320190763P

Feazer Cottage

Re: Documentation to support application for variation/removal of conditions relating to application number 3/2019/0217

Conditions to be varied or removed:

SJ Bialecki Limited Building Surveyors
Drawing no 6002/d
Scale 1:100
Proposed Site Layout
Proposed Residential Development On Land At Ribblesdale View Chatburn

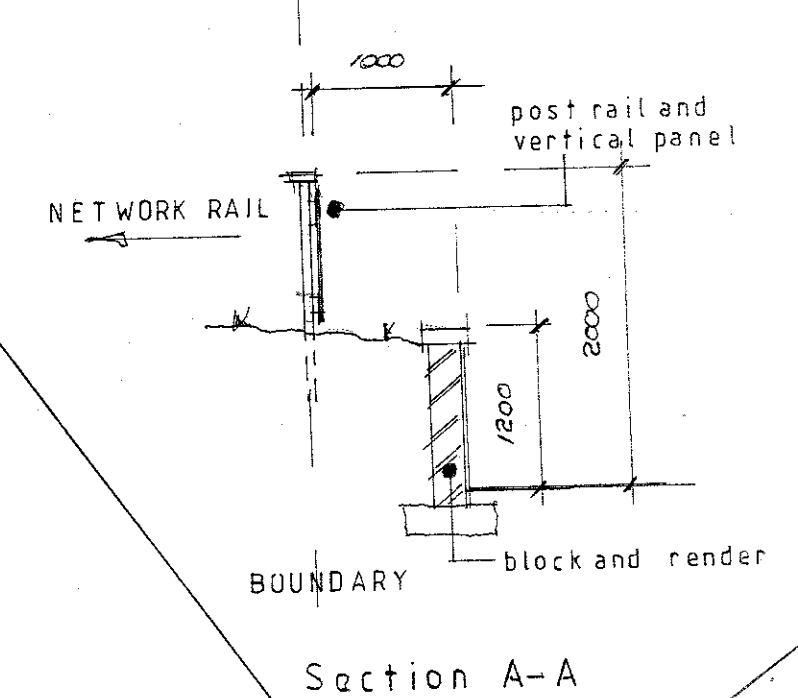
We would like to submit an application to vary this condition due to a redesign and reduction in property size by approximately 20% for Plot A, previous application which has now been withdrawn 03/2019/0476.

6002a Proposed site layout (This is due to plot a redesign)

6002d Proposed site layout (showing redesign for Plot A)
